EL PASO COUNTY STORMWATER MANAGEMENT PLAN CHECKLIST

EPC Project Number: PPR-21-046

Revised: July 2019

DUTCH BROS. COFFEE - CO0707 - PEYTON, CO INITIAL EROSION CONTROL PLAN

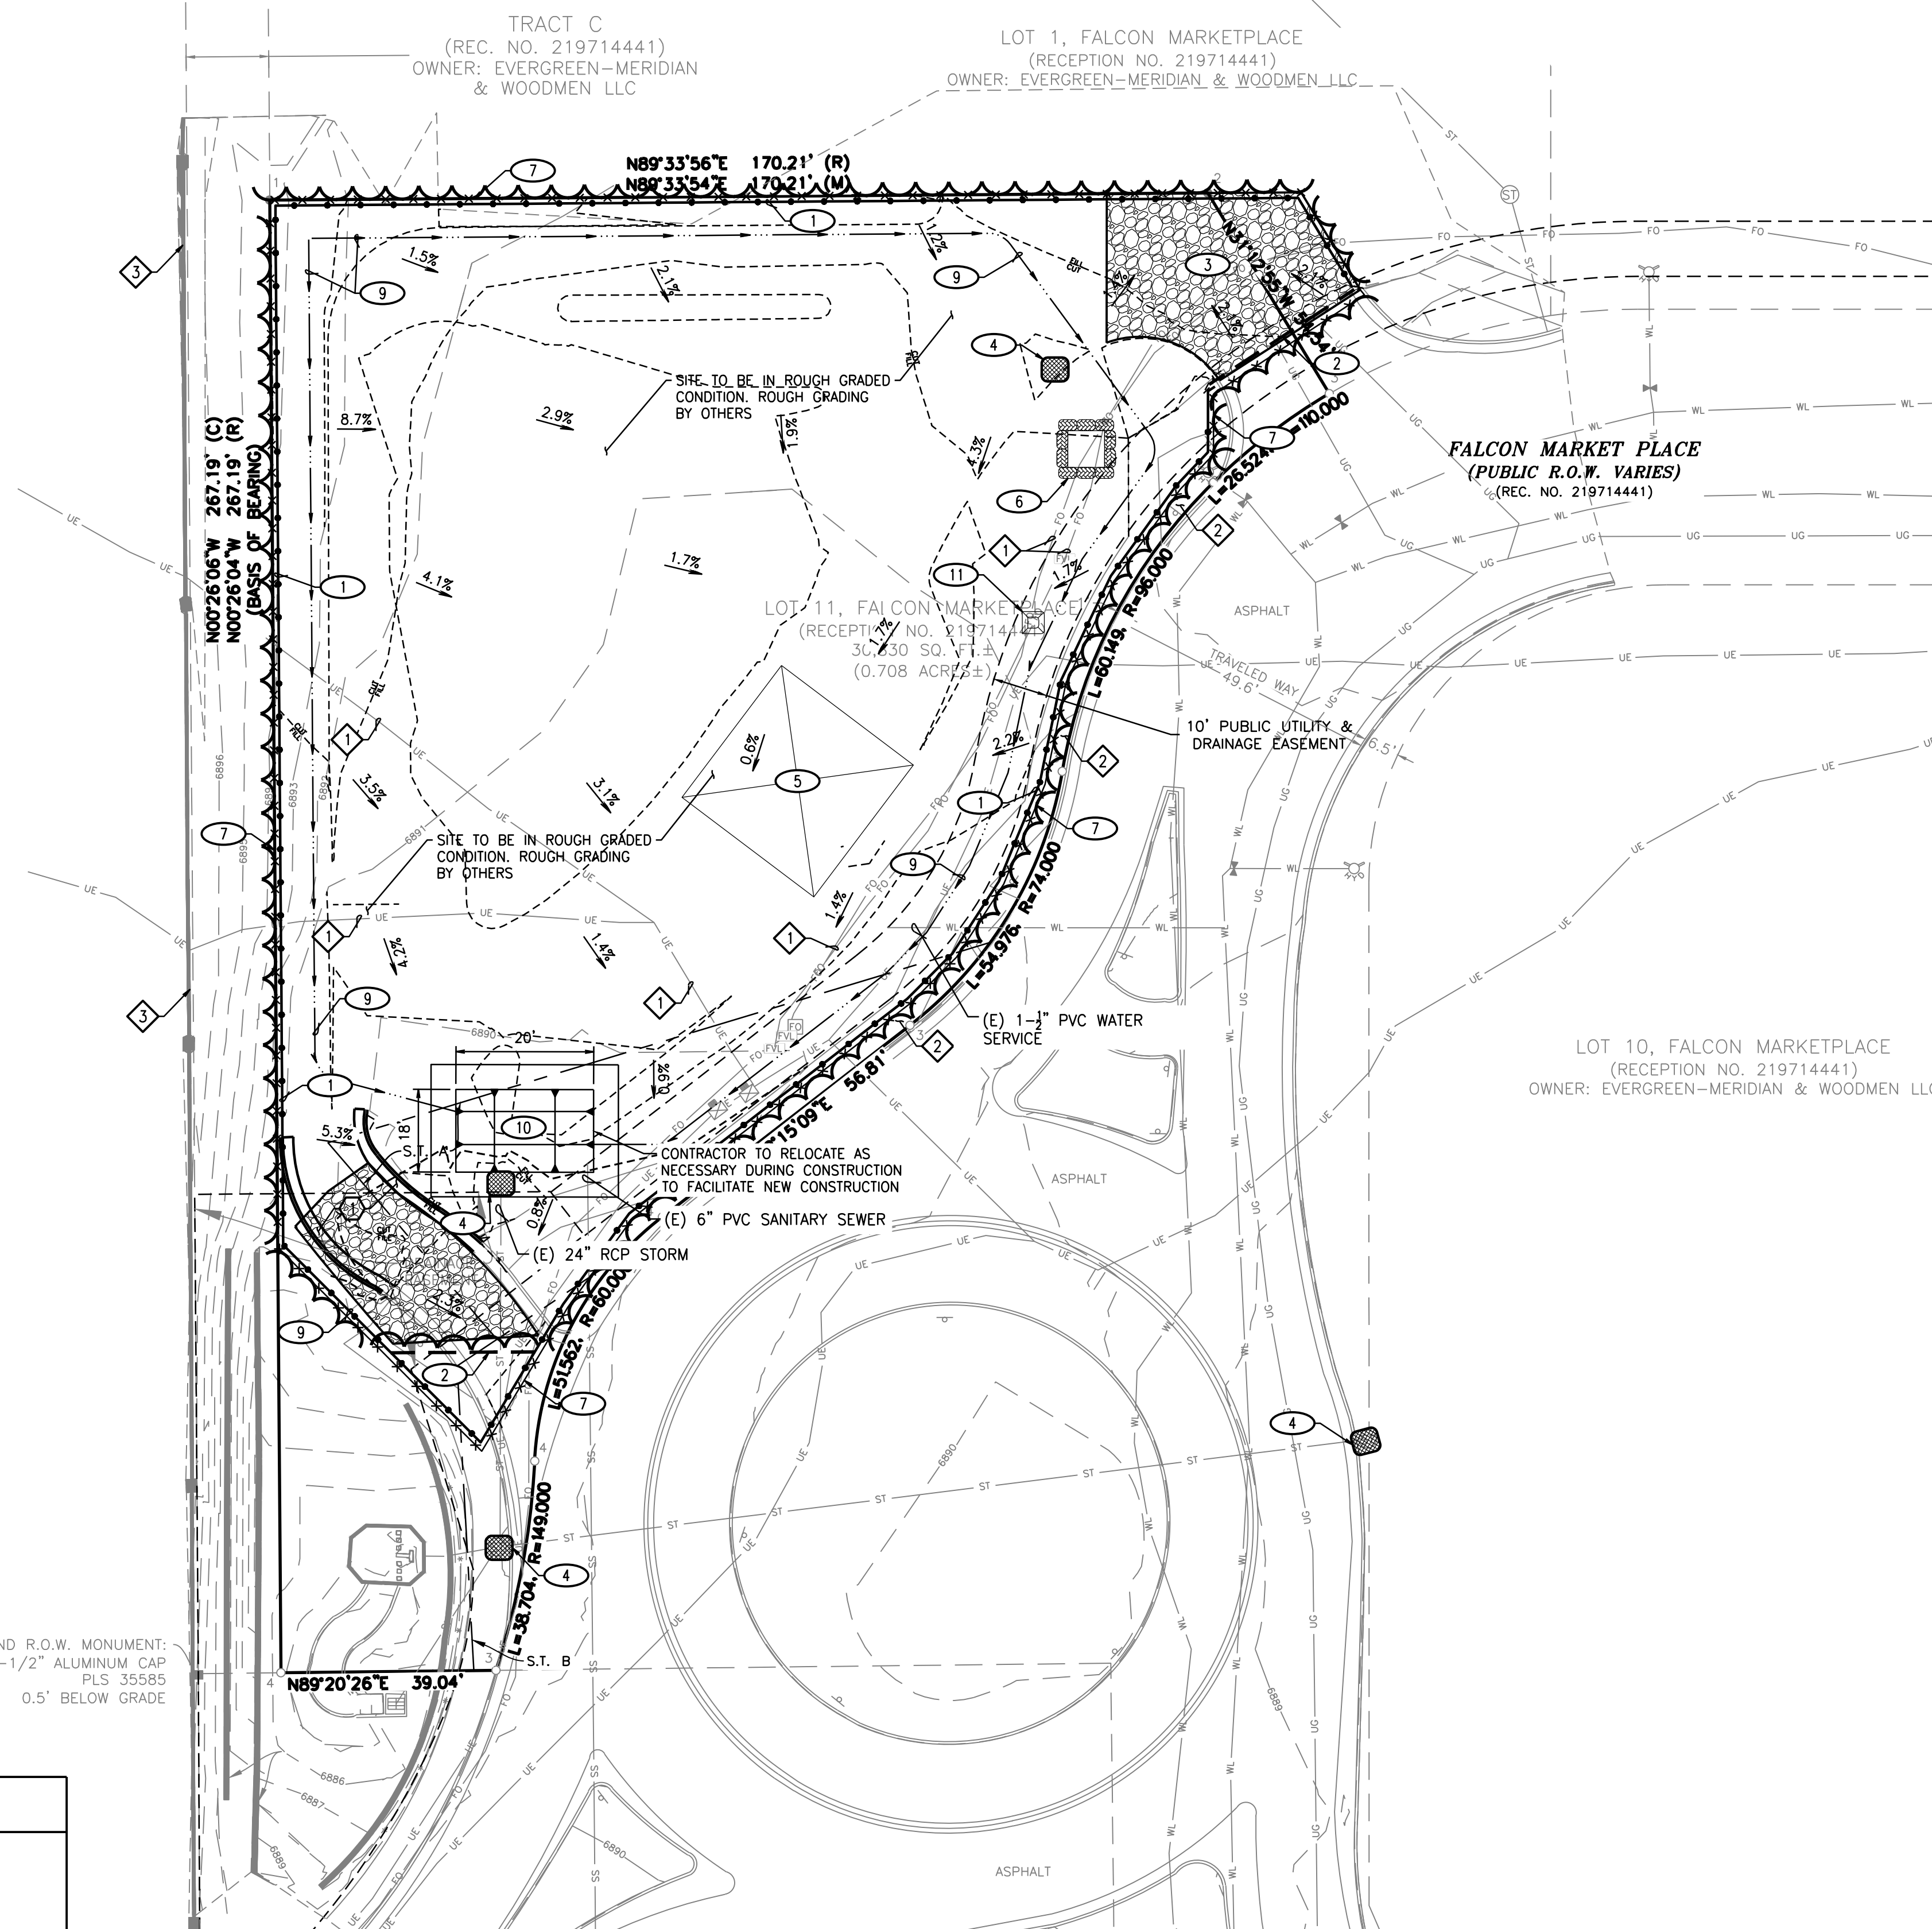
Applicant	EPC
17	SWMP Map to include: reviewed Construction Drawings_v1		
17a	construction site boundaries		X
17b	flow arrows to depict stormwater flow directions		✓
17c	all areas of disturbance		X
17d	areas of cut and fill		✓
17e	areas used for storage of building materials, soils (stockpiles) or wastes		✓
17f	location of any dedicated asphalt / concrete batch plants No batch plants proposed		X
17g	location of all structural control measures		✓
17h	location of all non-structural control measures		✓
17i	springs, streams, wetlands and other surface waters, including areas that require maintenance of pre-existing vegetation within 50 feet of a receiving water No surface waters identified		X
18	Narrative description of all structural control measures to be used. Modifications to EPC standard control measures must meet or exceed County-approved details		X
19	Description of all non-structural control measures to be used including seeding, mulching, protection of existing vegetation, site watering, sod placement, etc.		X

## DUTCH BROS. COFFEE - CO0707 - PEYTON, CO EROSION CONTROL DETAILS

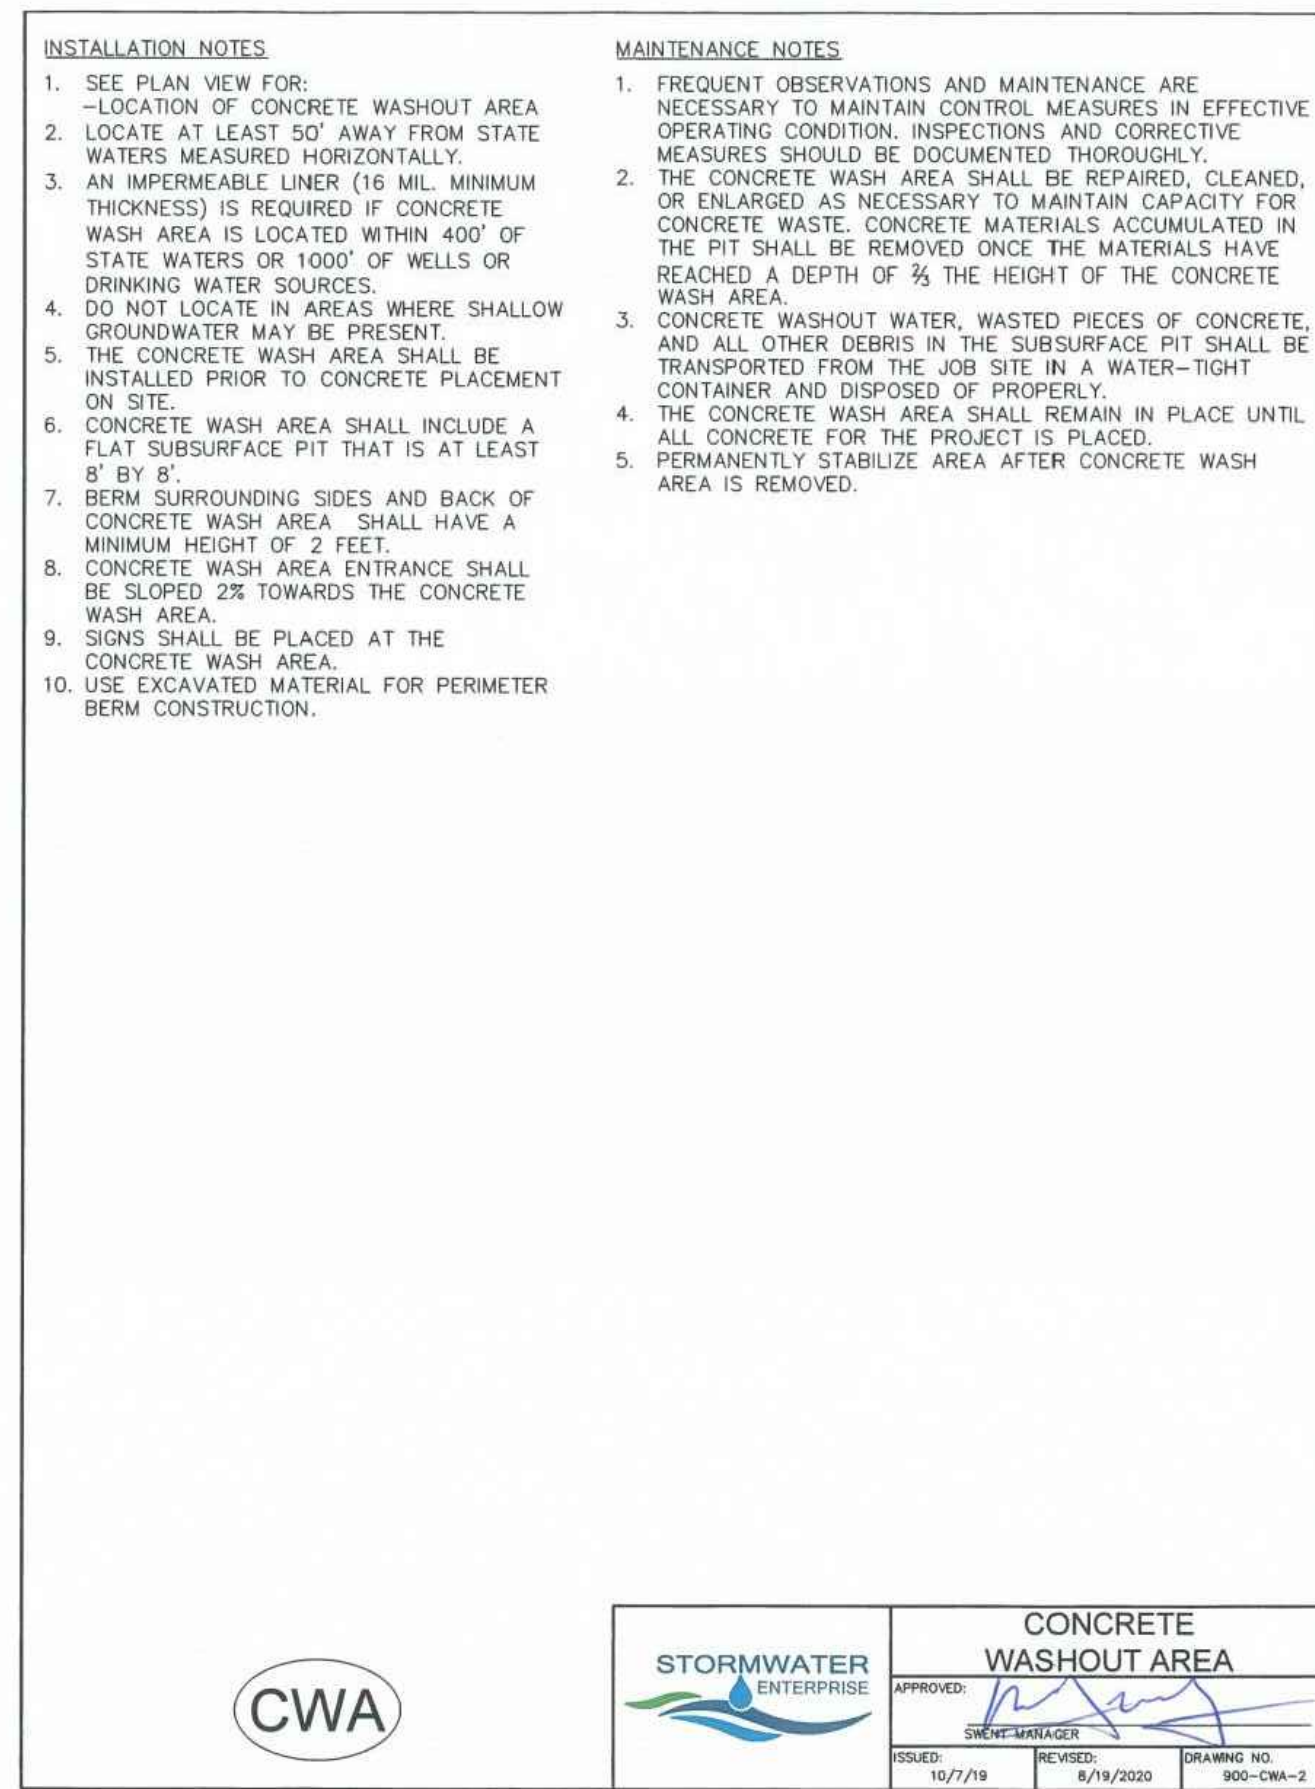
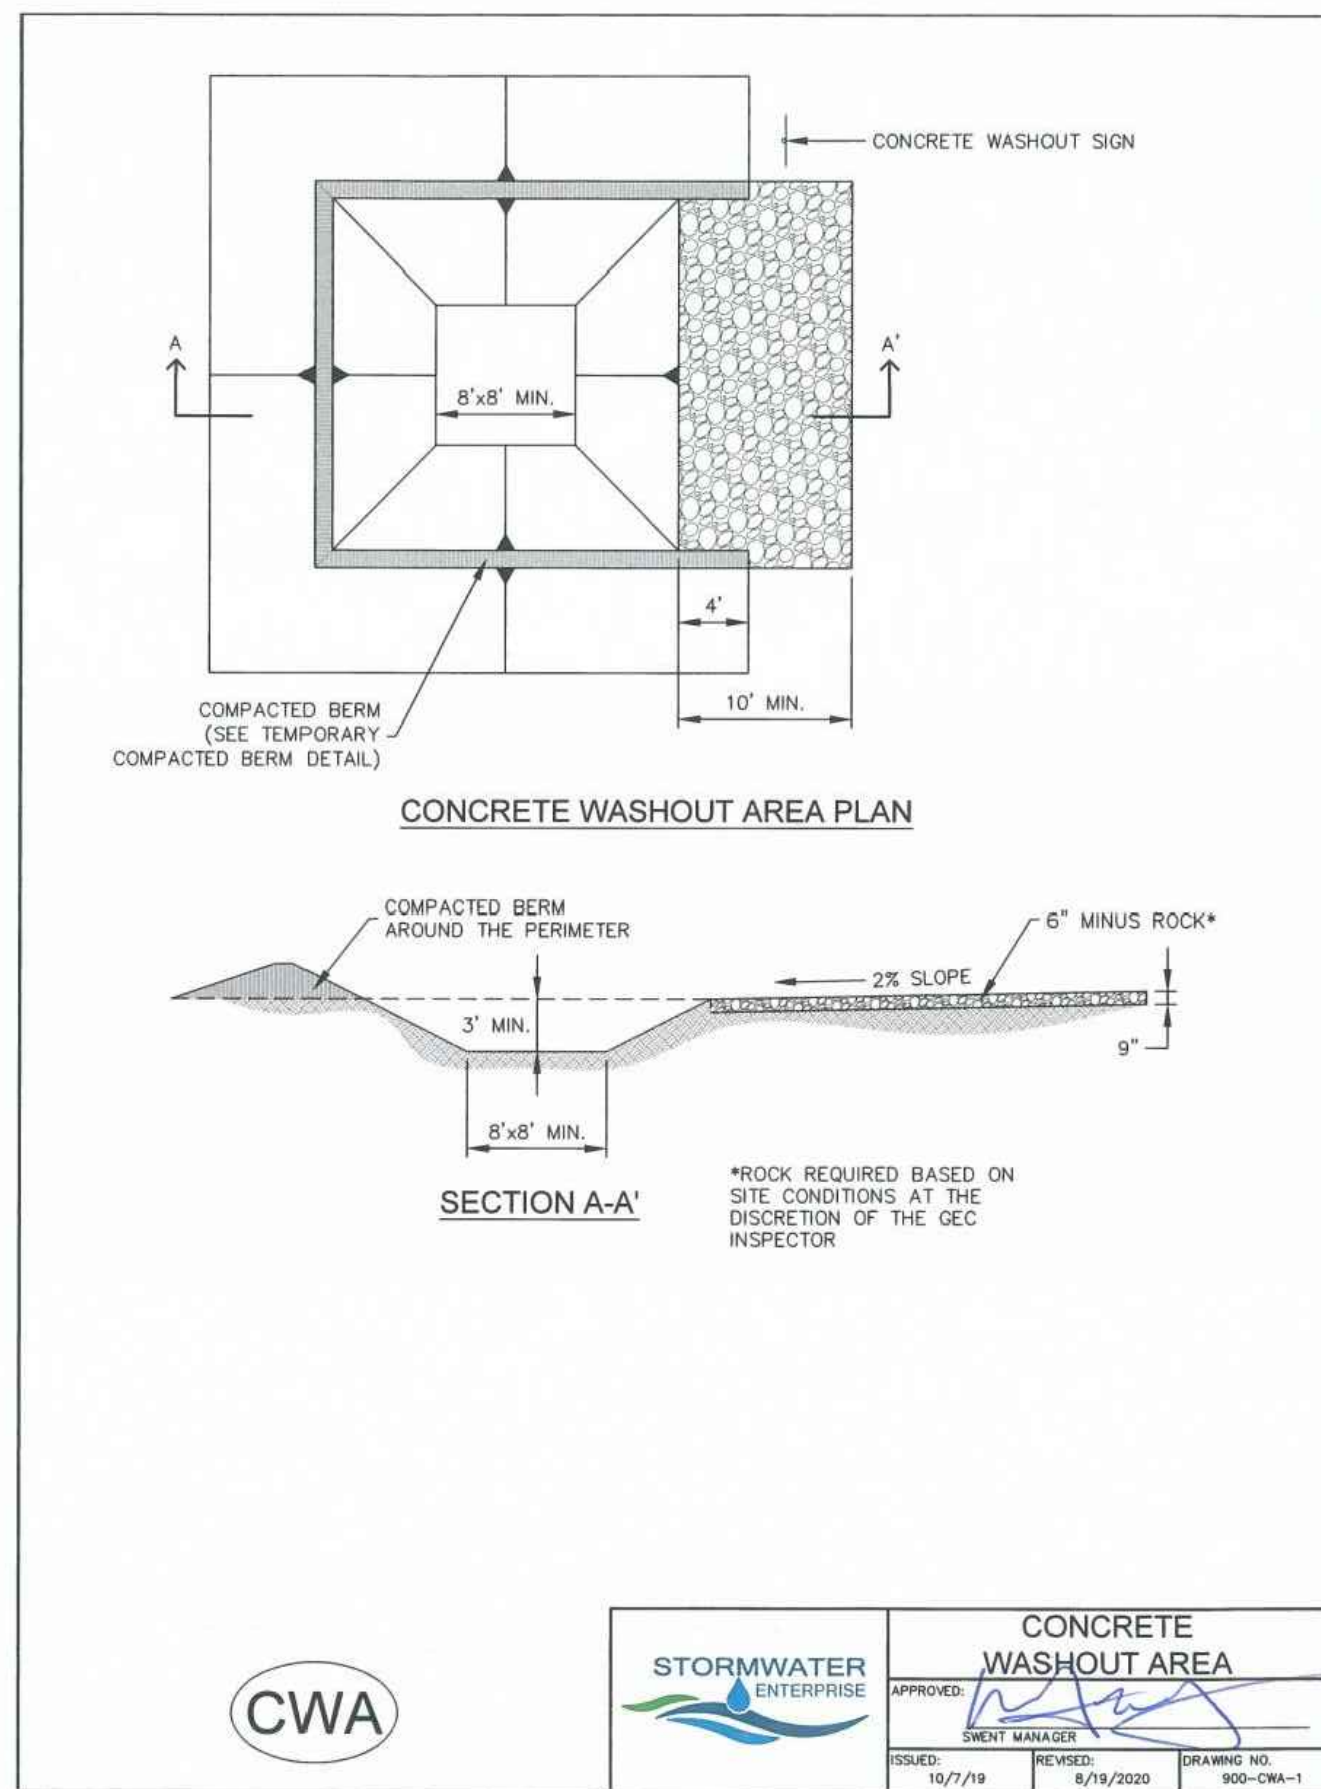
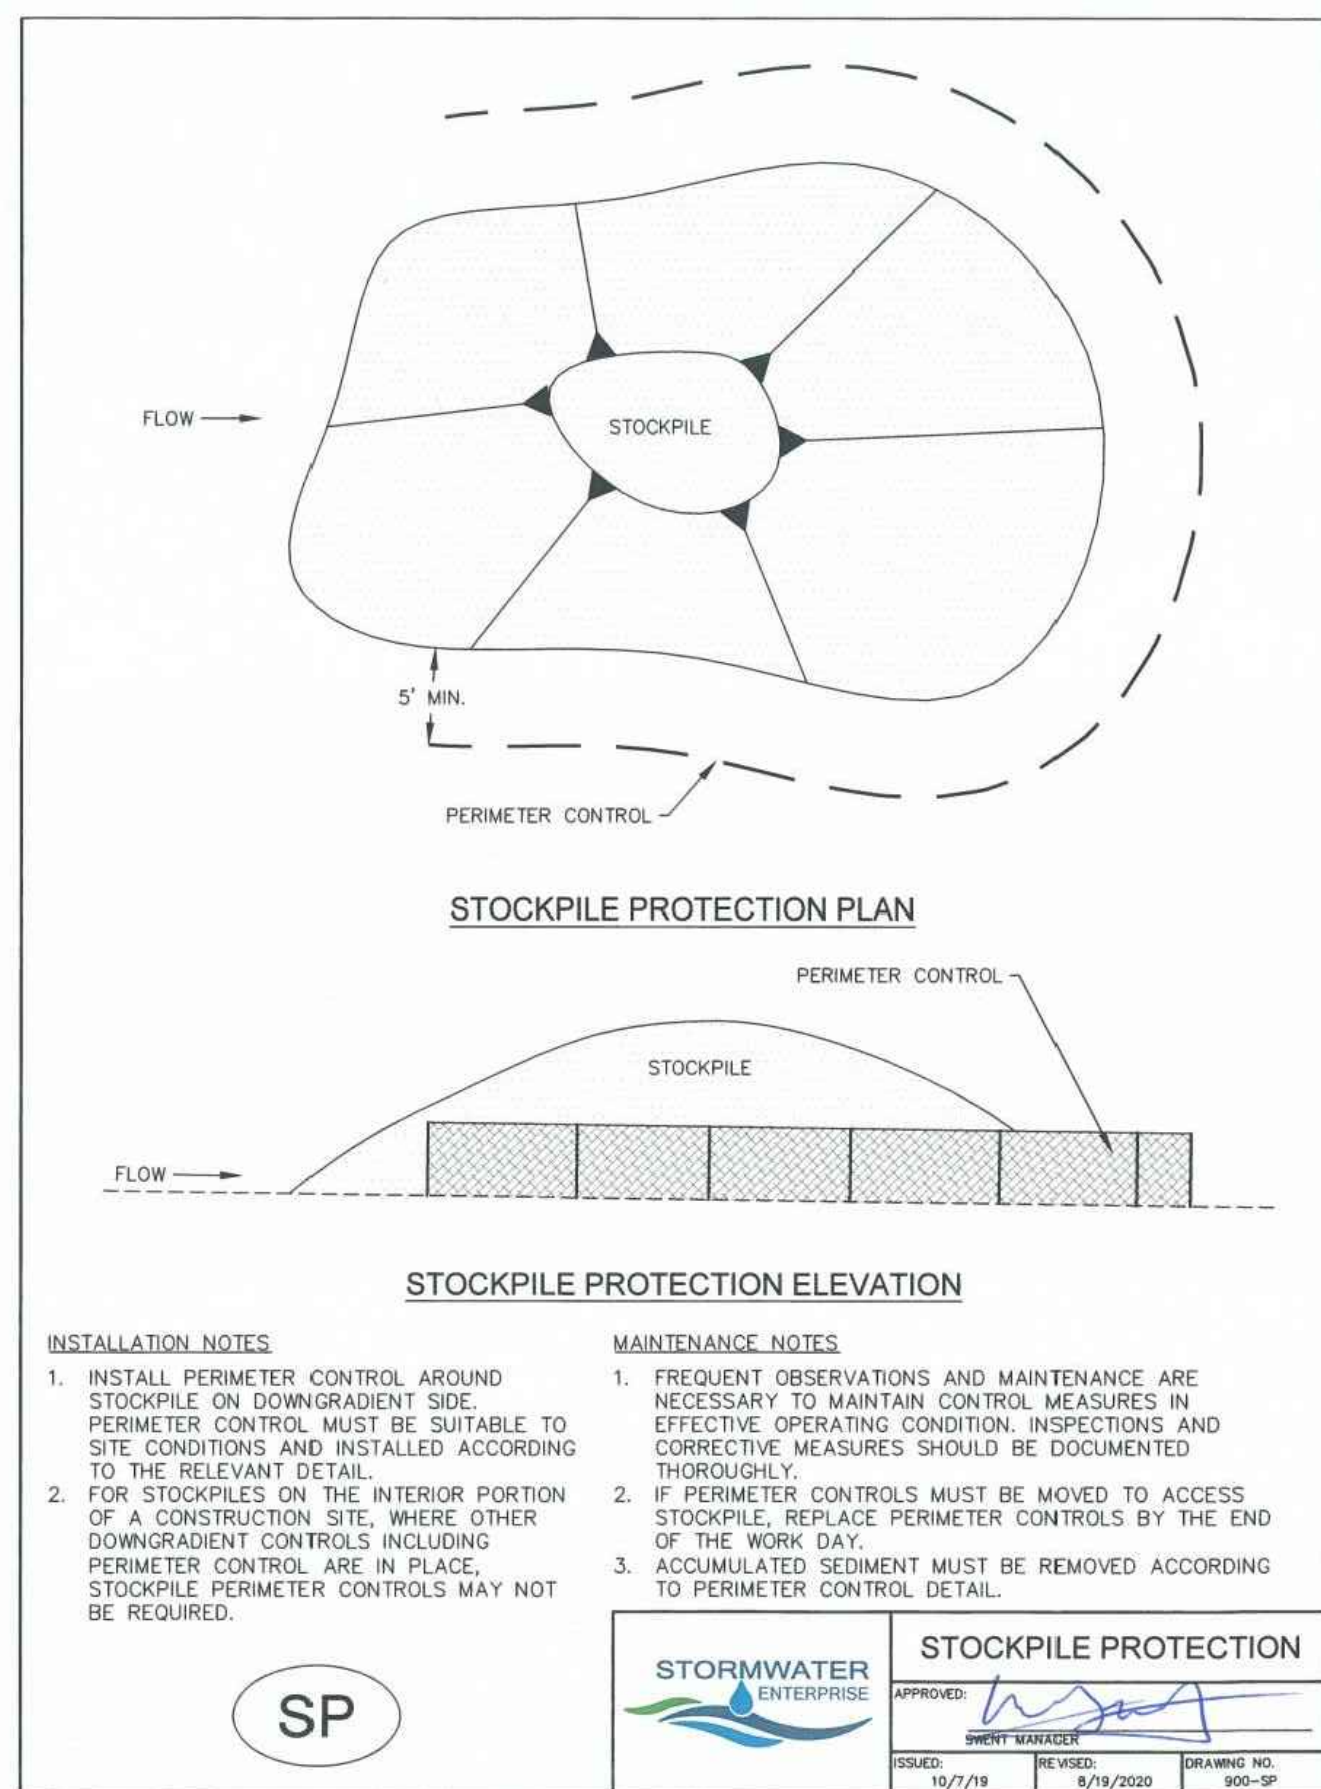
20	Technical drawing details for all control measure installation and maintenance; custom or other jurisdiction's details used must meet or exceed EPC standards		X
21	Procedure describing how the SWMP is to be revised		X
22	Description of Final Stabilization and Long-term Stormwater Quality (describe nonstructural and structural measures to control SW pollutants after construction operations have been completed, including detention, water quality control measure etc.)		X
23	Specification that final vegetative cover density is to be 70% of pre-disturbed levels		✓
24	Outline of permit holder inspection procedures to install, maintain, and effectively operate control measures to manage erosion and sediment		✓
25	Record keeping procedures identified to include signature on inspection logs and location of SWMP records on-site		X
26	If this project relies on control measures owned or operated by another entity, a documented agreement must be included in the SWMP that identifies location, installation and design specifications, and maintenance requirements and responsibility of the control measure(s)		✓
